Subject: Planning application AW/272/19/HH

My husband and I live at 49 Westminster Drive and have just seen the planning application for number 51 Westminster Drive, the middle of our block of three houses.

Drawing:
DESIGN PROPOSALS

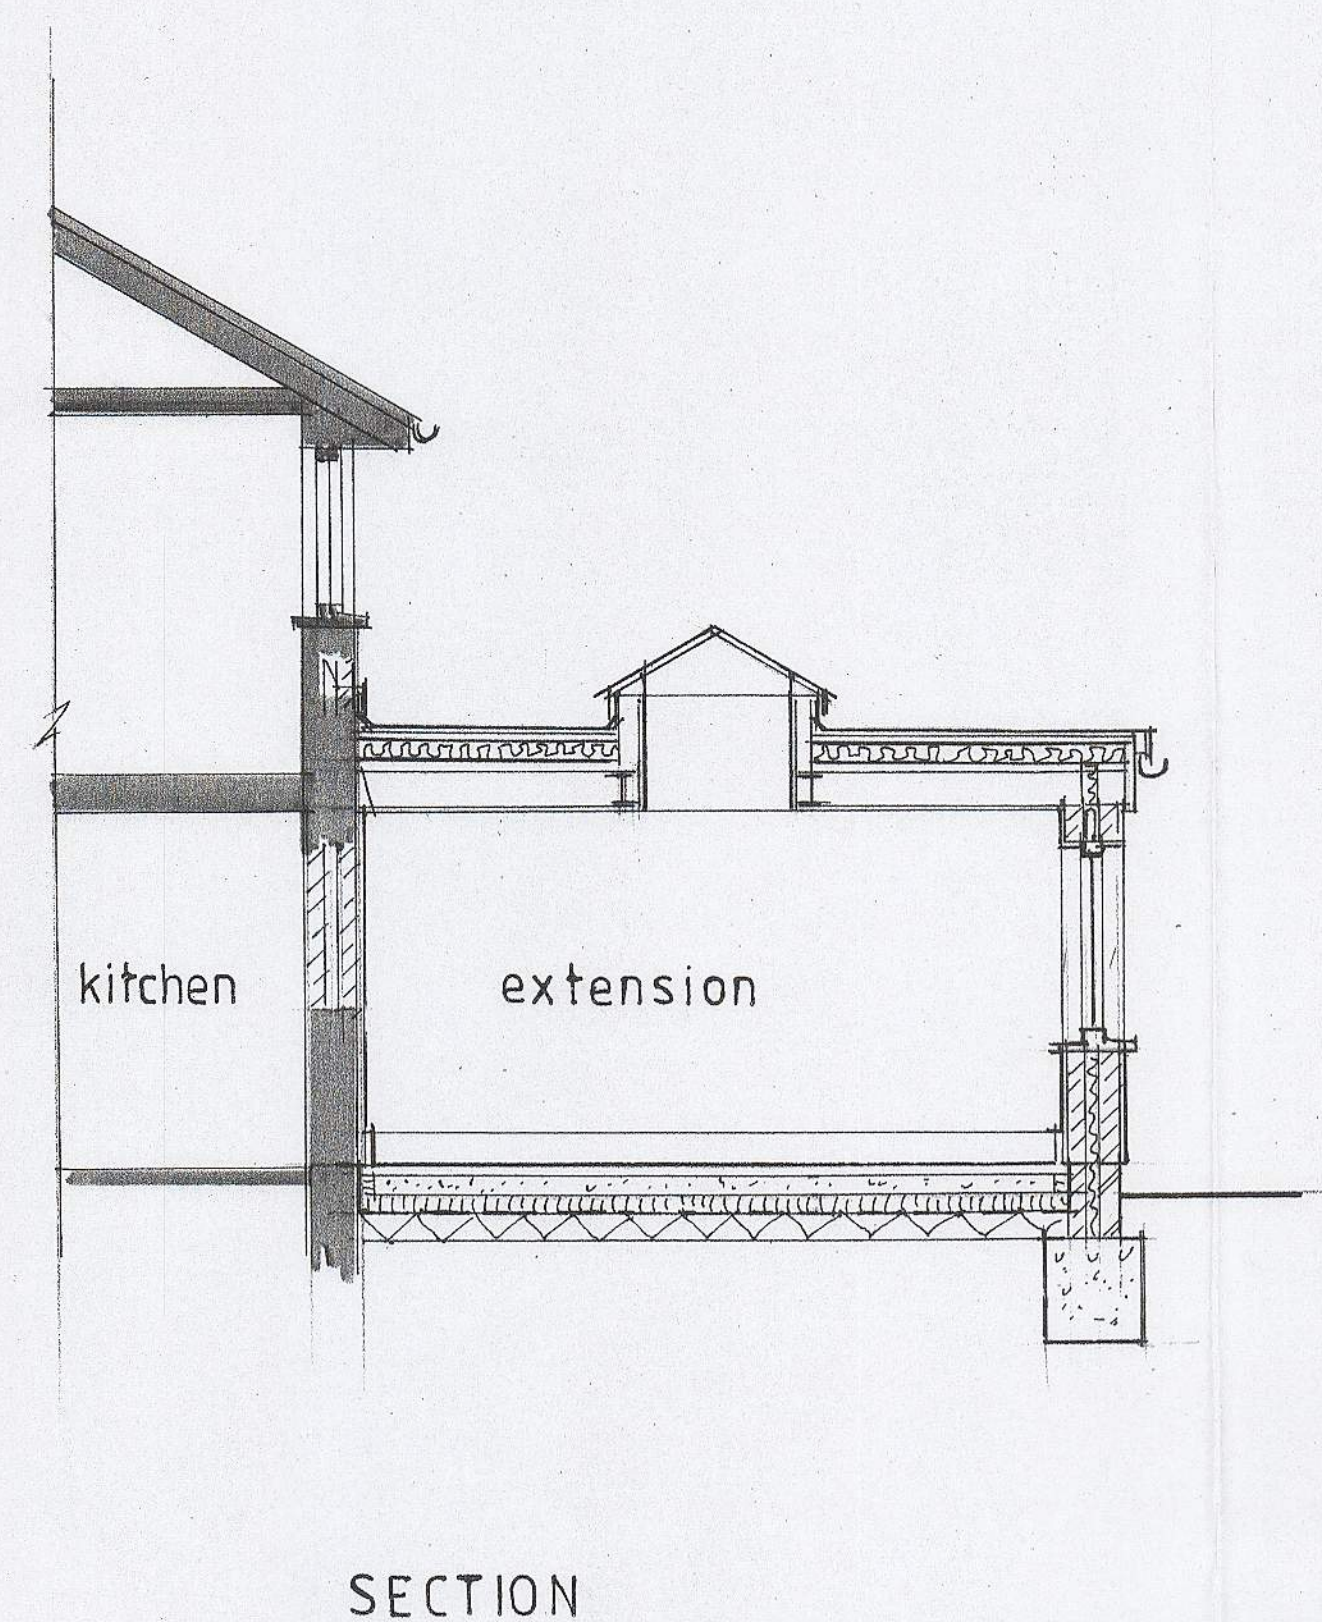
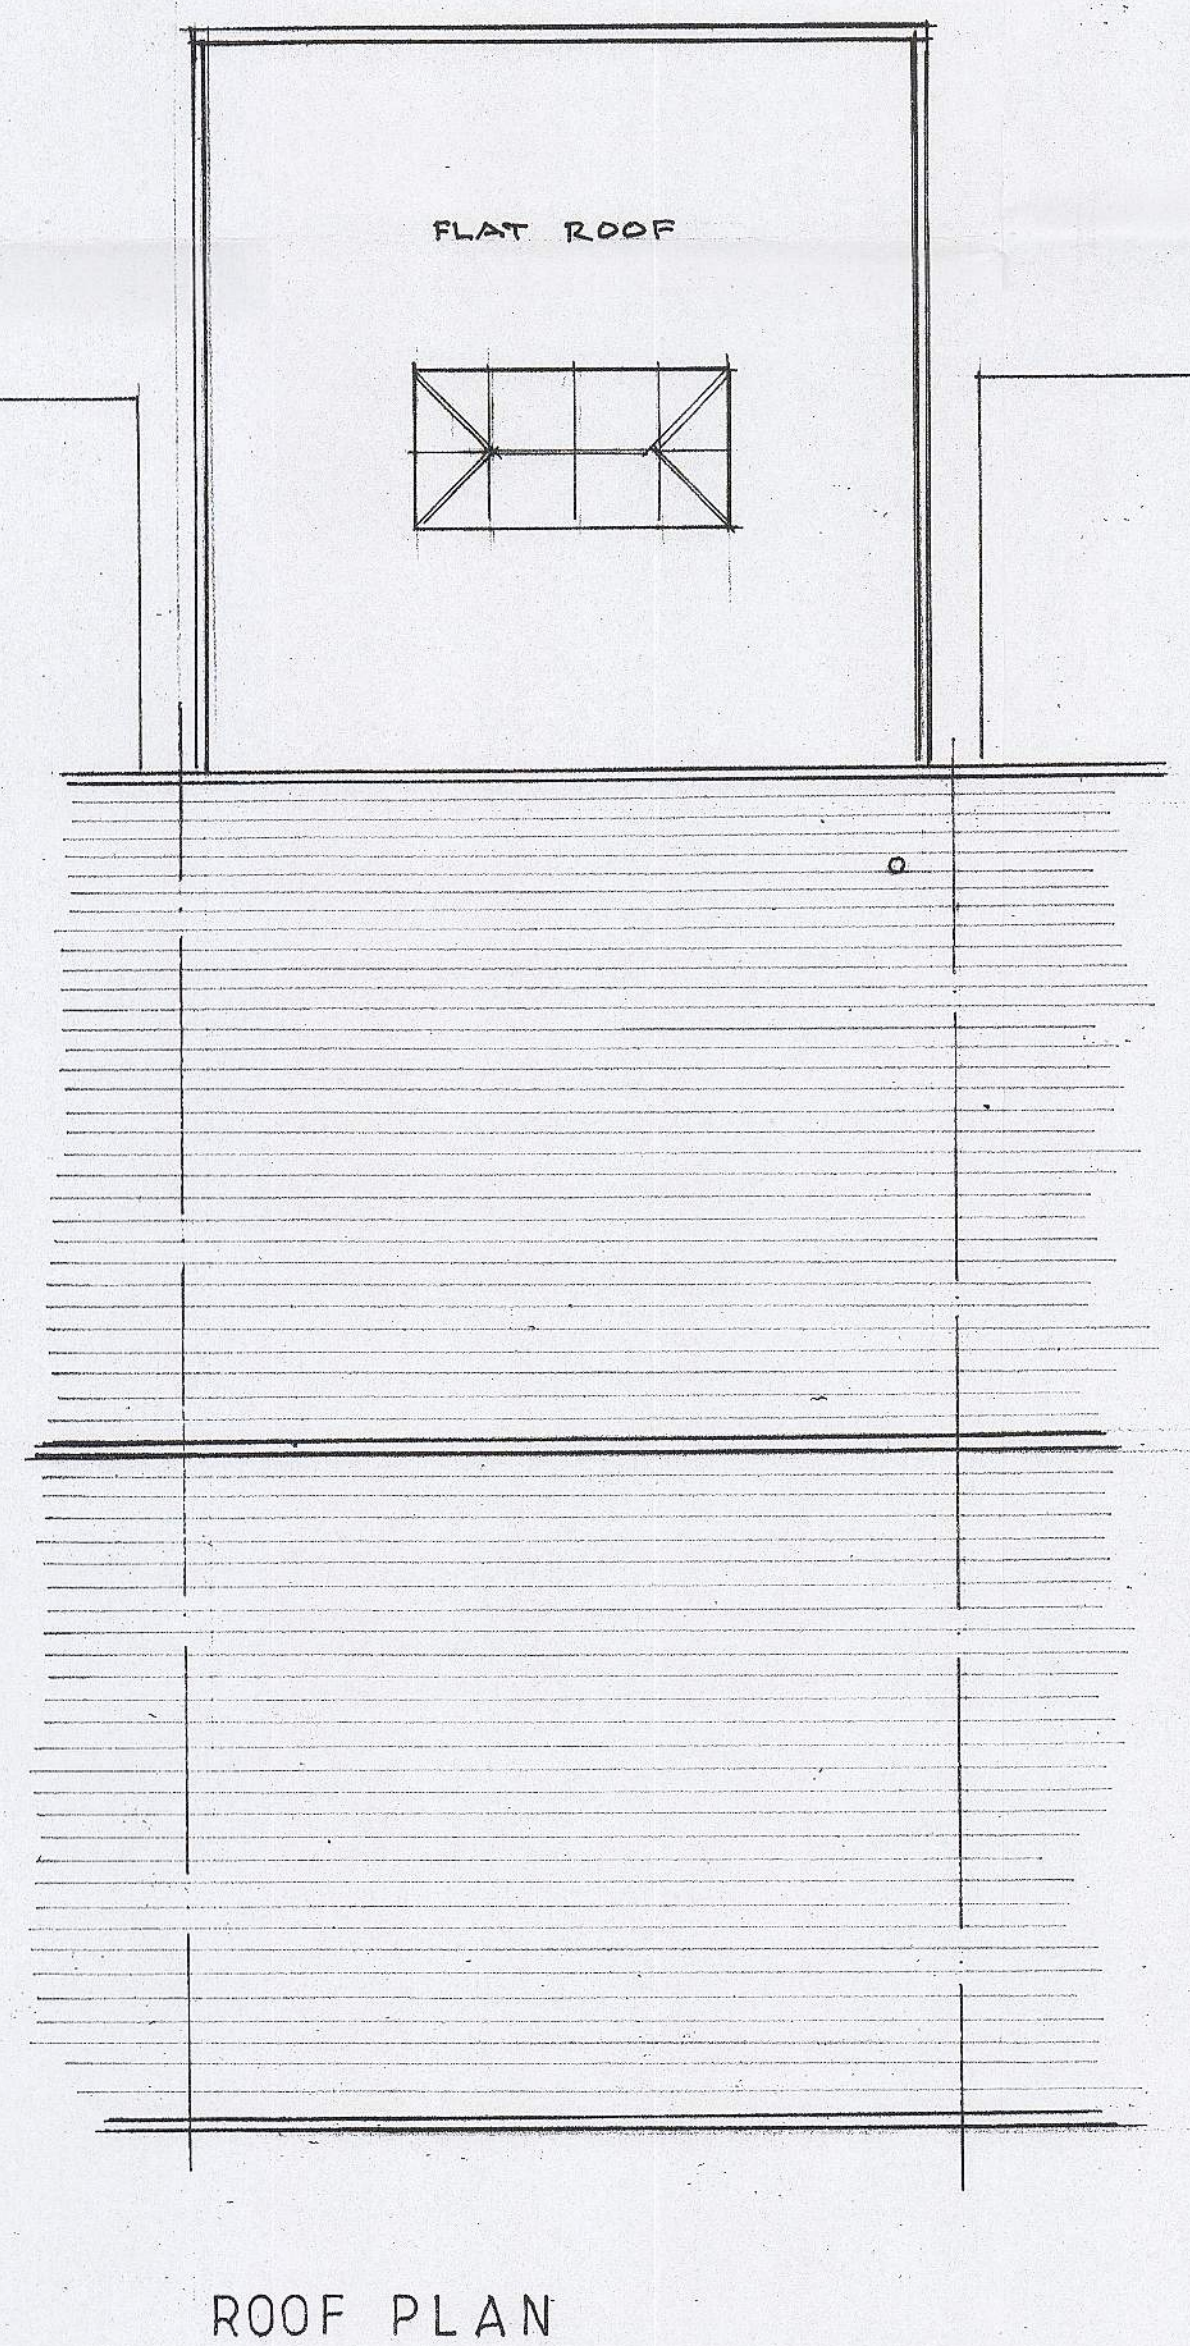
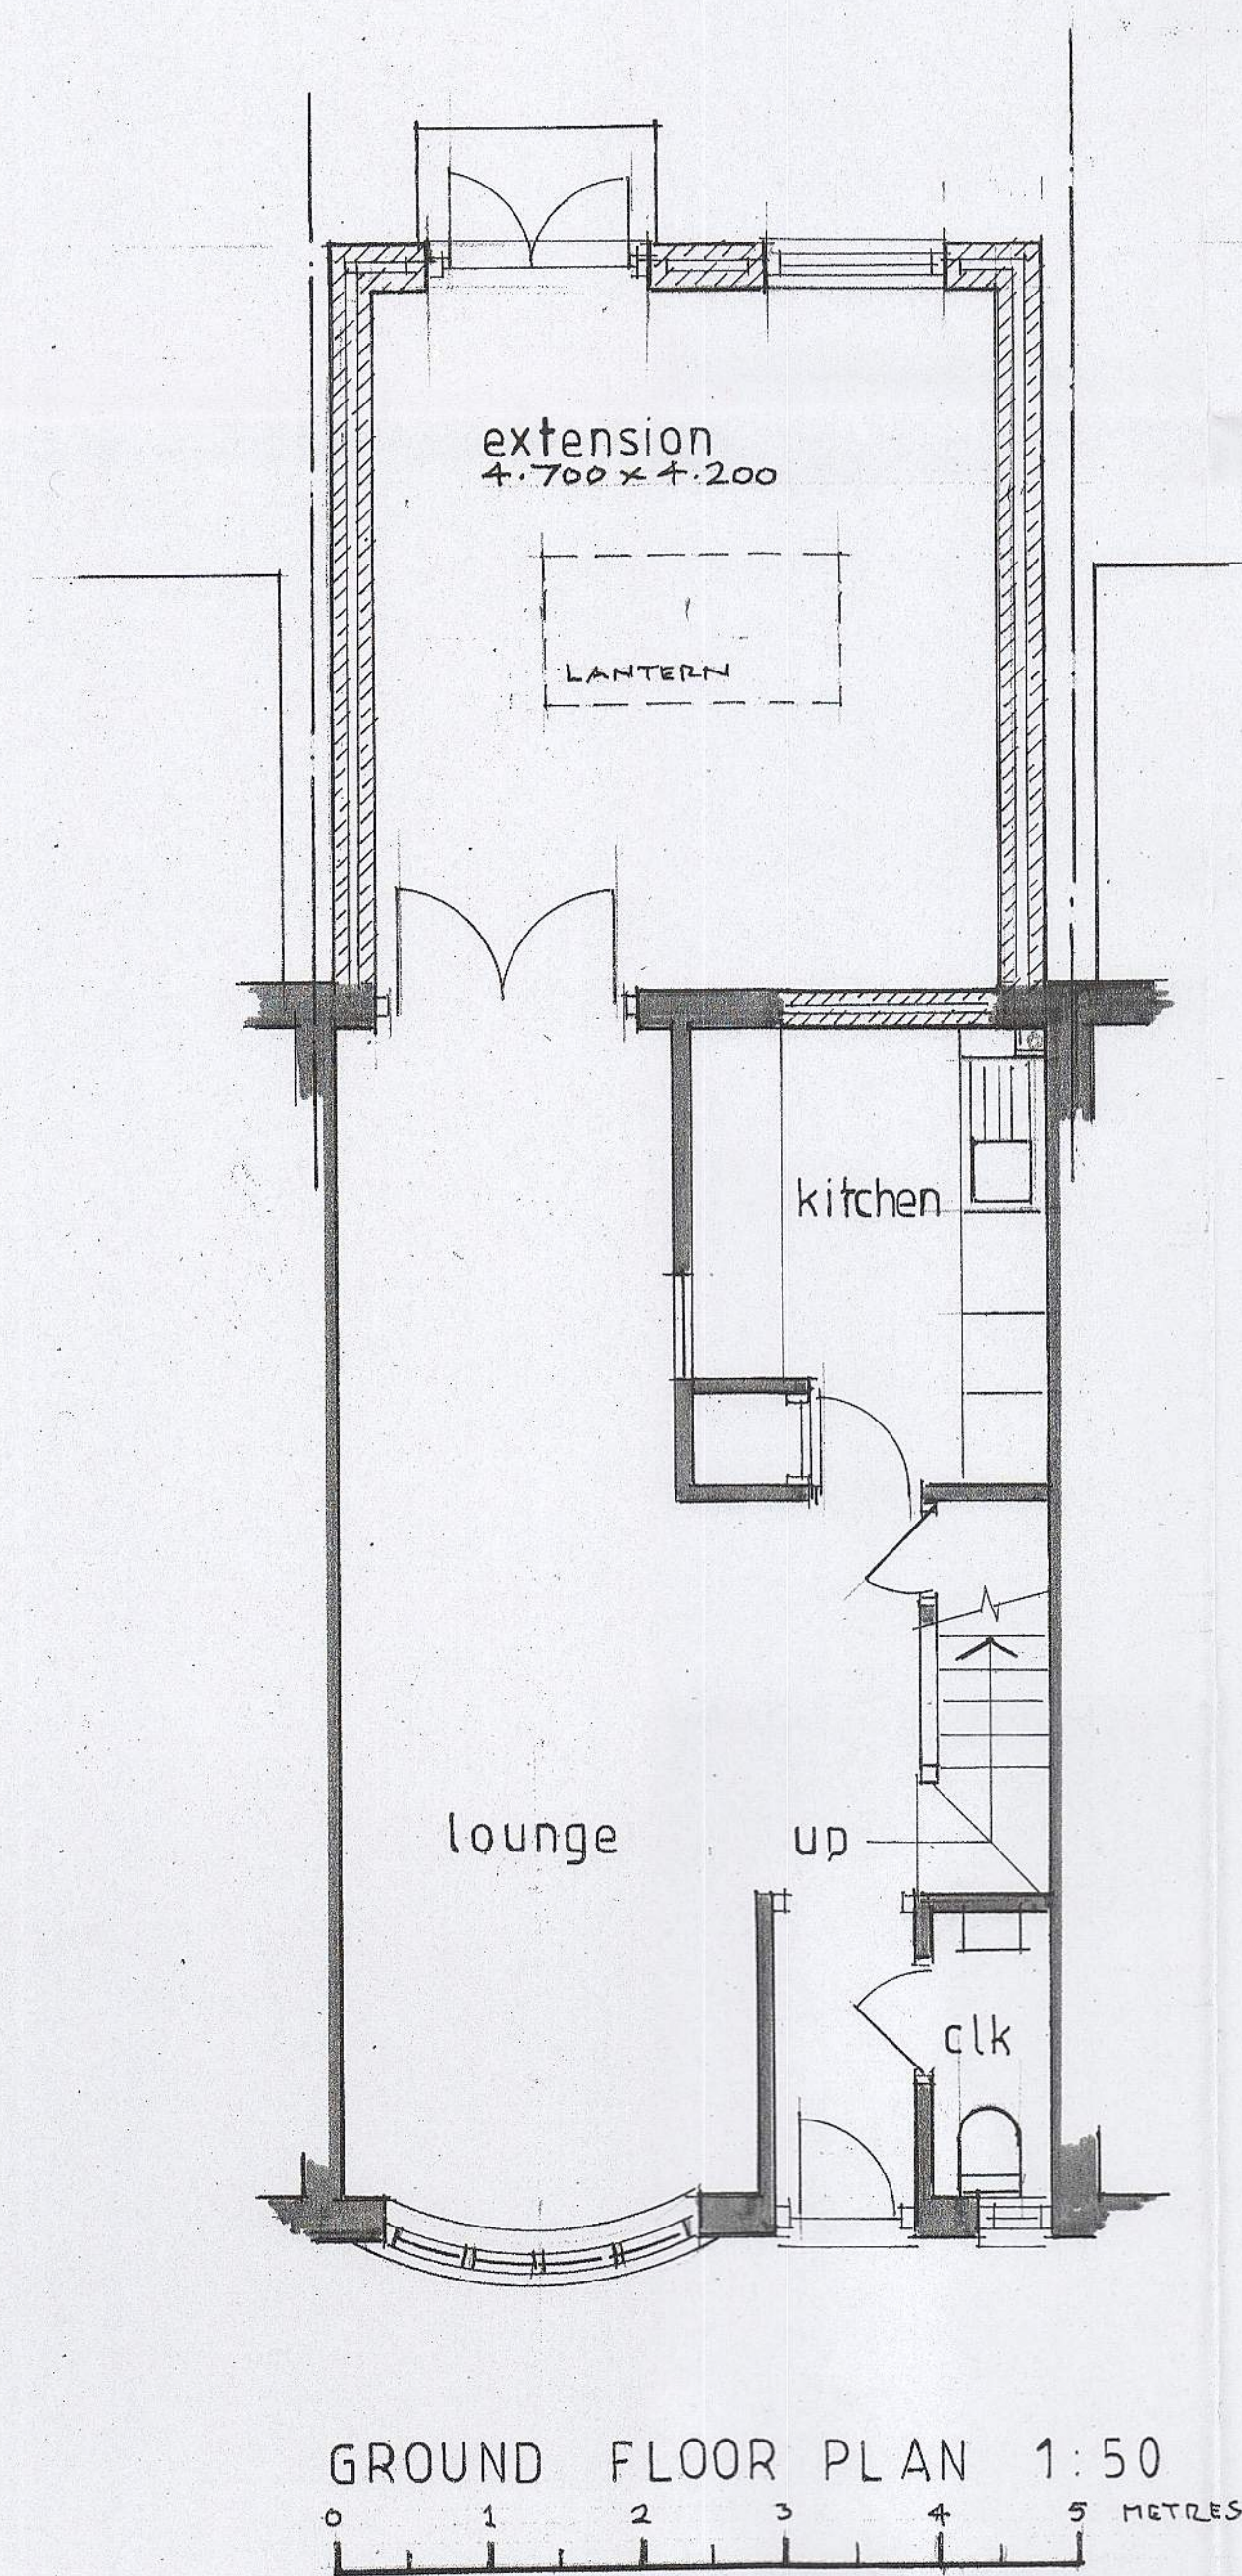
It has come to our attention that a previous owner of number 51 has slabbed over the foul water inspection cover serving our property. This cover is was just over the boundary line of our property and on to his.

There is a foul water drain for all three adjoined properties which runs under the ground about 2.5 metres out from the back walls of number 51 and 53.

We are worried therefore that the builders and architect will not be aware that a foul water drain with relevant inspection covers runs along the back of these two properties as there is no visual evidence of this.

I am also aware that due care and special measures need to be taken when building above a foul water drain run to protect the drain from collapse.

Whilst we have no objection to an extension we would like all necessary precautions to be taken and the foul water inspection cover to be re instated in an accessible position.
